CITY LINK TRUCKING

225 N. CURTIS RD. COLORADO SPRINGS, CO SITE DEVELOPMENT PLAN

ARCHITECTURAL SITE PLAN

PPR2339

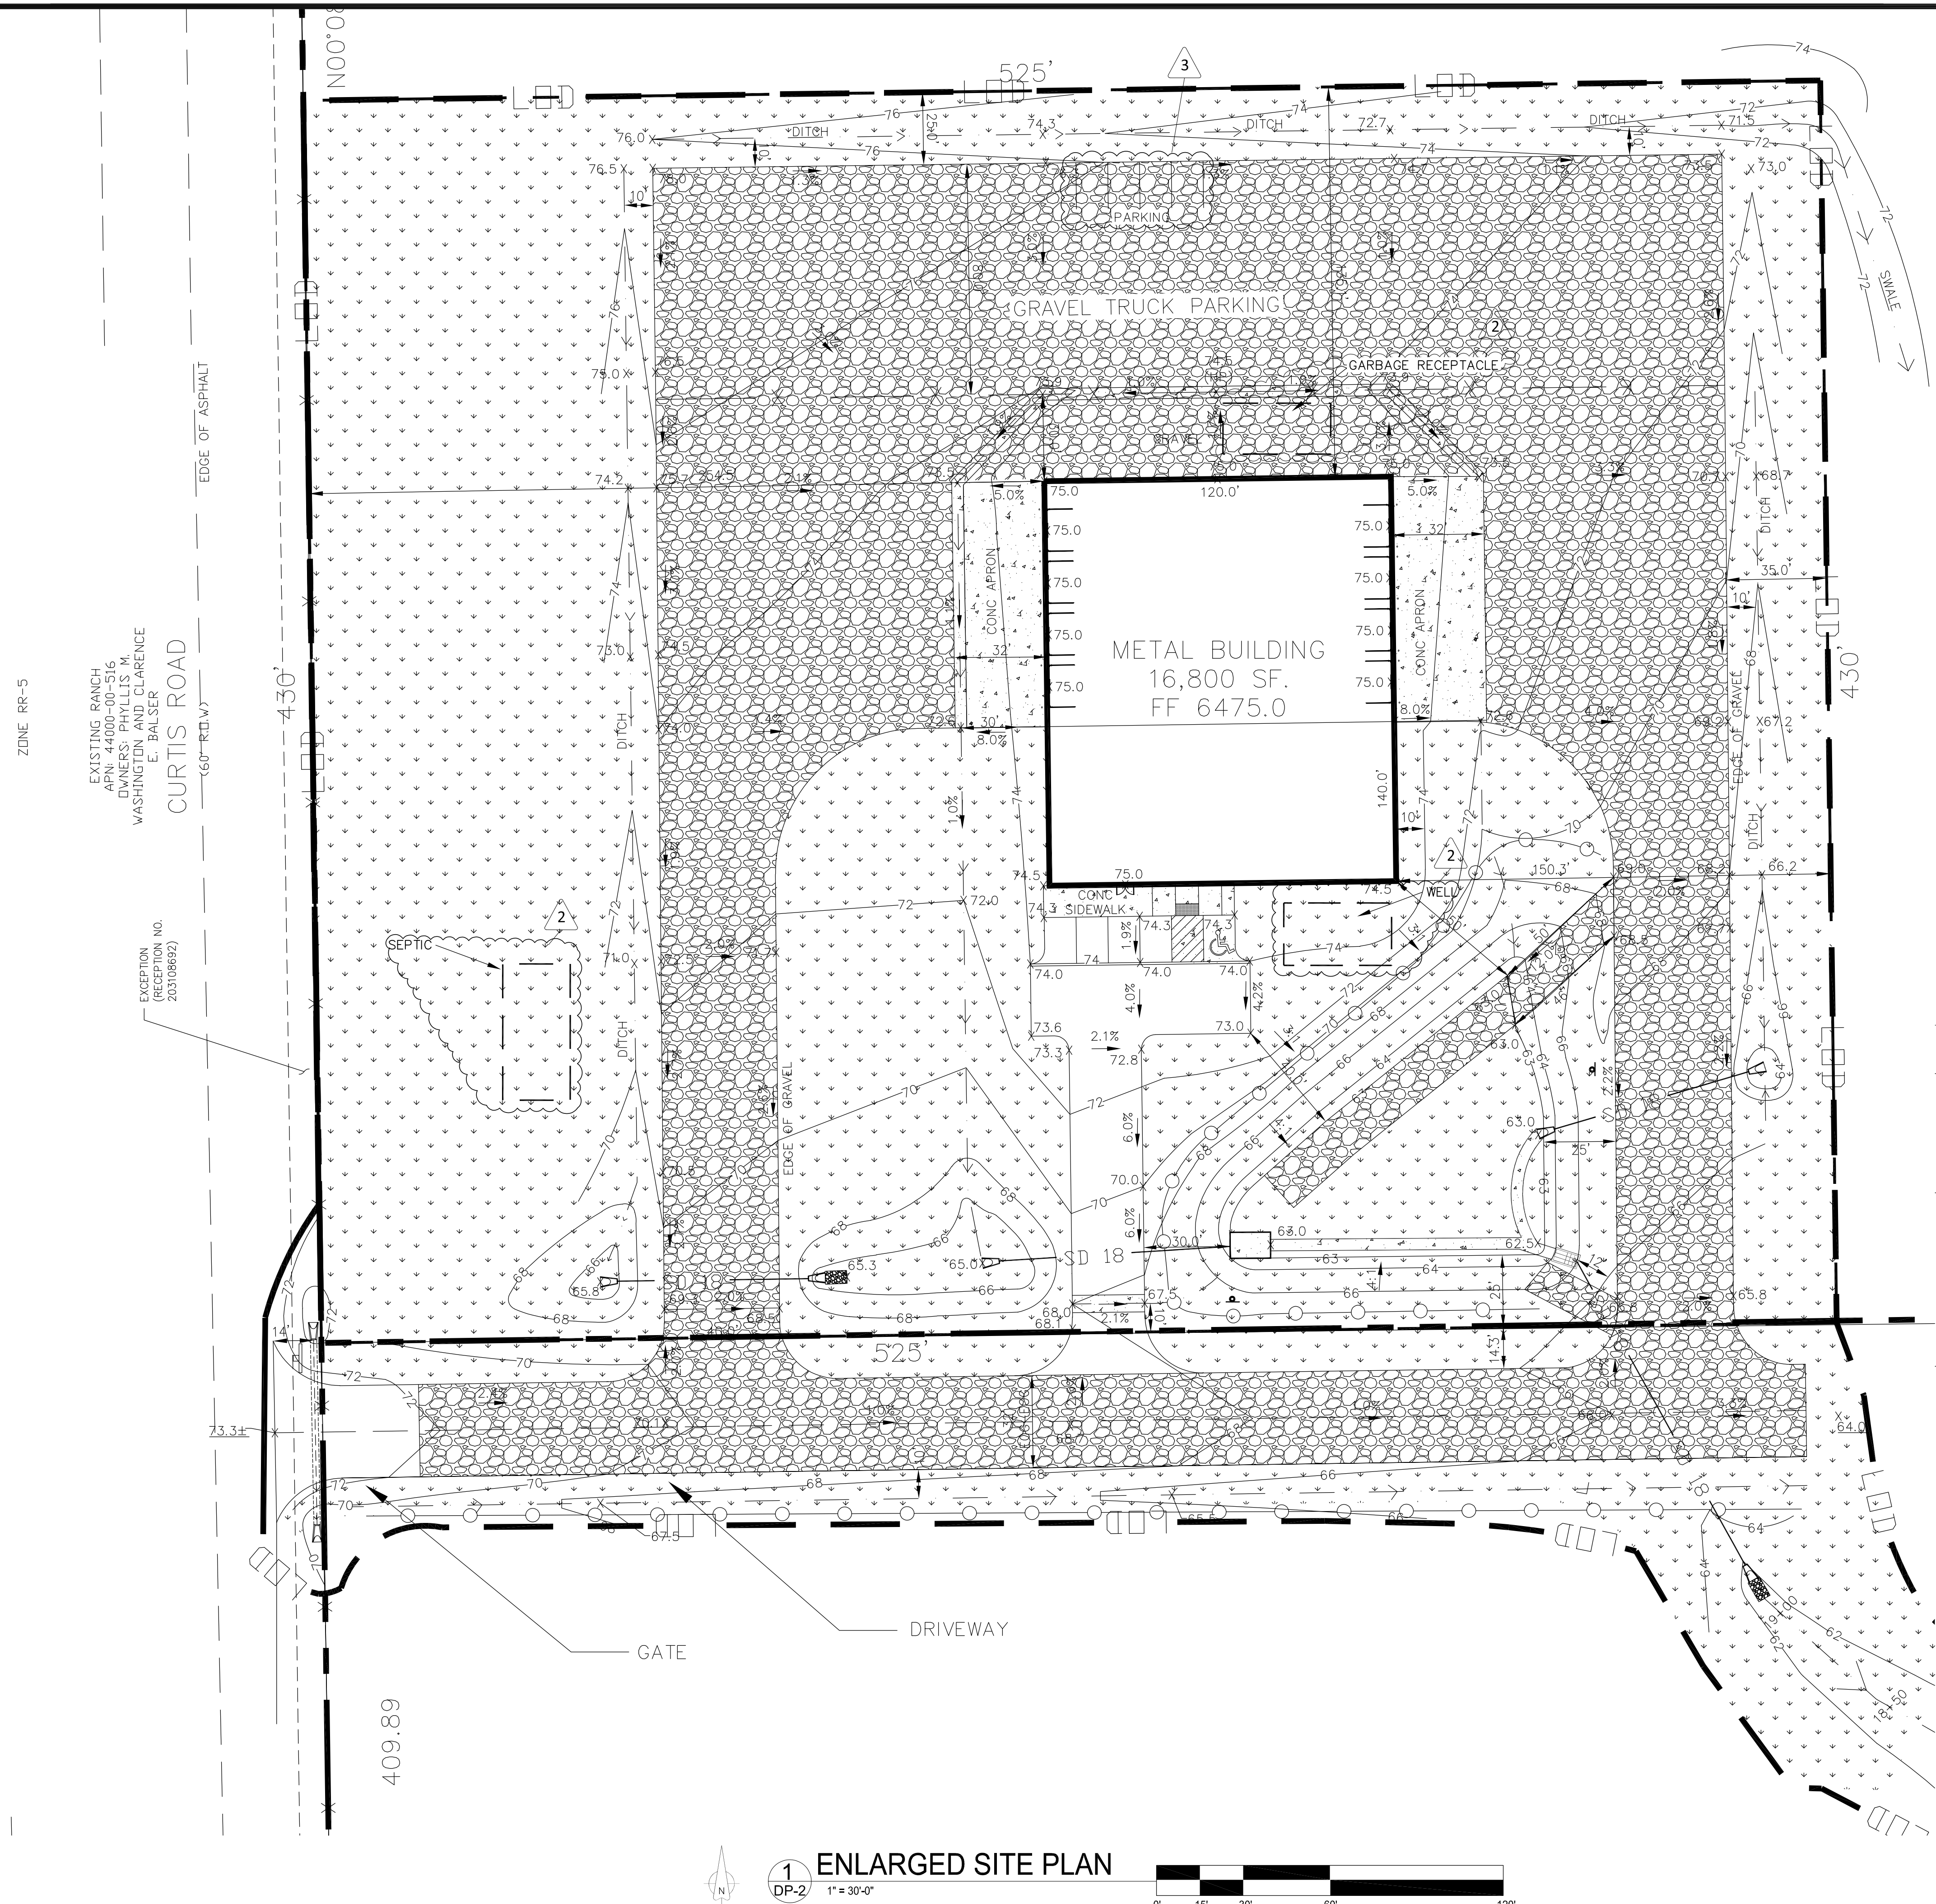
Unresolved V1 comments:

- locations of well/septic infrastructure
- locations of garbage receptacles/screening mechanisms
- location of no build areas, floodplains or drainage ways (if none, then specify)
- height of office and storage buildings

V2:

- Please make sure that setback measurements can be easy to read and are bolded
- please add legend to this page
